Subject: RE: Planning Consultation on BE/60/19/DOC

Engineers Comments Regarding Condition 4- surface water drainage

182 Chichester Road Bersted PO21 5BJ

Approval of details reserved by condition imposed under ref BE/66/16/PL relating to Condition Nos 3 - schedule of materials & finishes, 4 - surface water drainage, 5 - landscaping, 6 - screen fences and 7 - secure storage of bicycles.

Client
Simon Abbot
Drawing Title
Surface Water Drainage

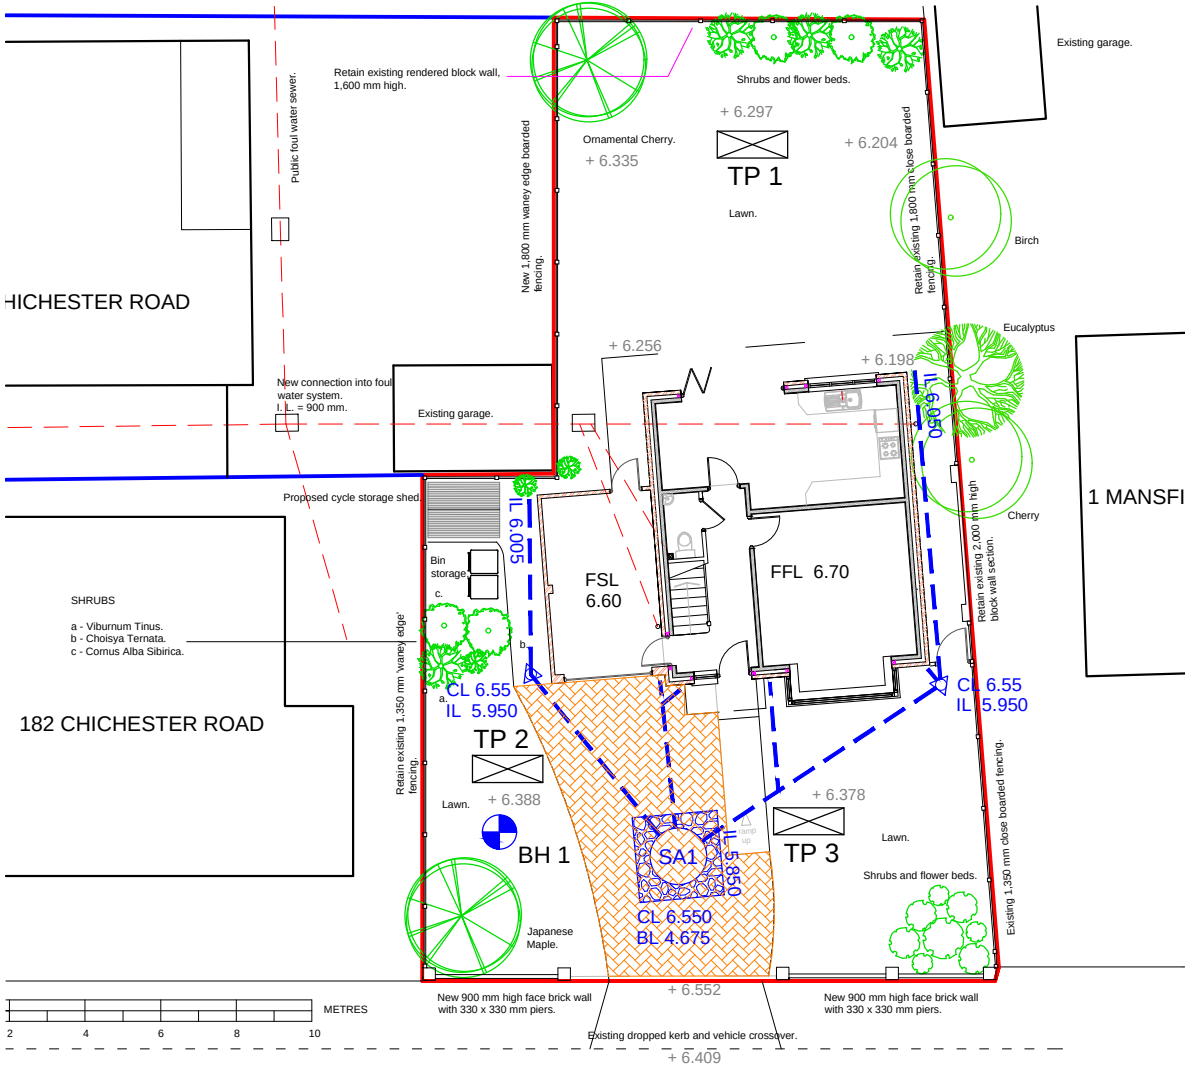
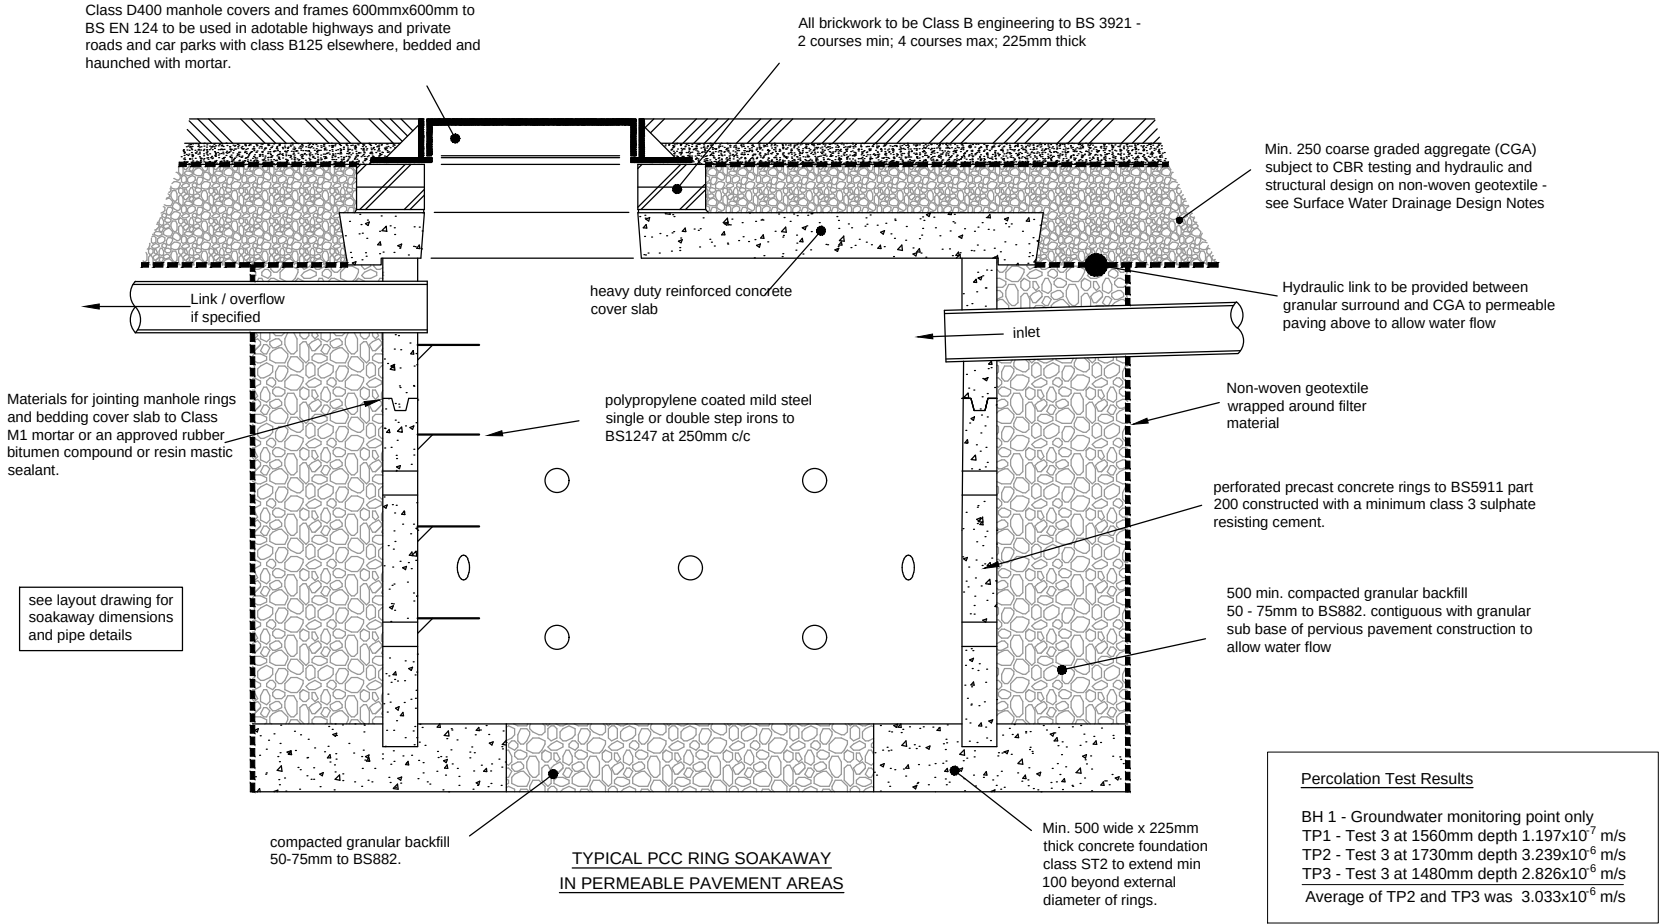
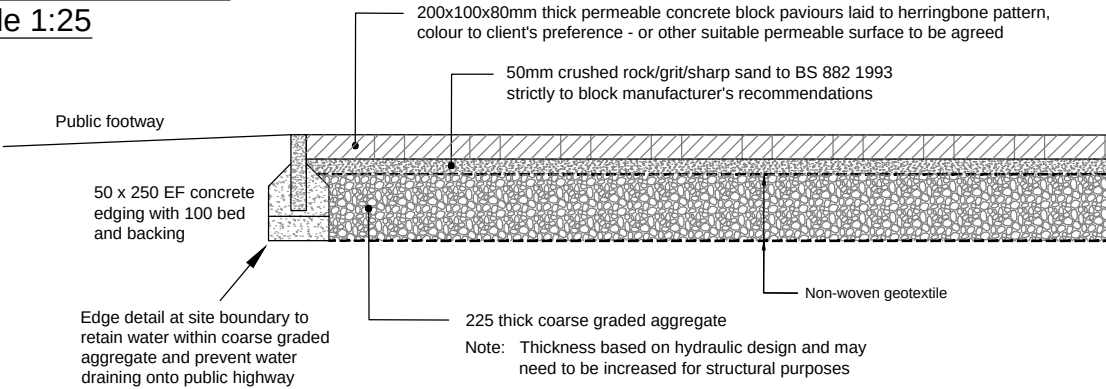
- No calculations have been submitted with the application. Please can these be provided.
- Average infiltration rates have been used in design. We require worst case results to be used. Please can further detail on the infiltration testing results be submitted, i.e. depths and locations of testing and results.
- It is unclear if winter groundwater monitoring has been completed. Please can the applicant confirm the duration of groundwater monitoring.
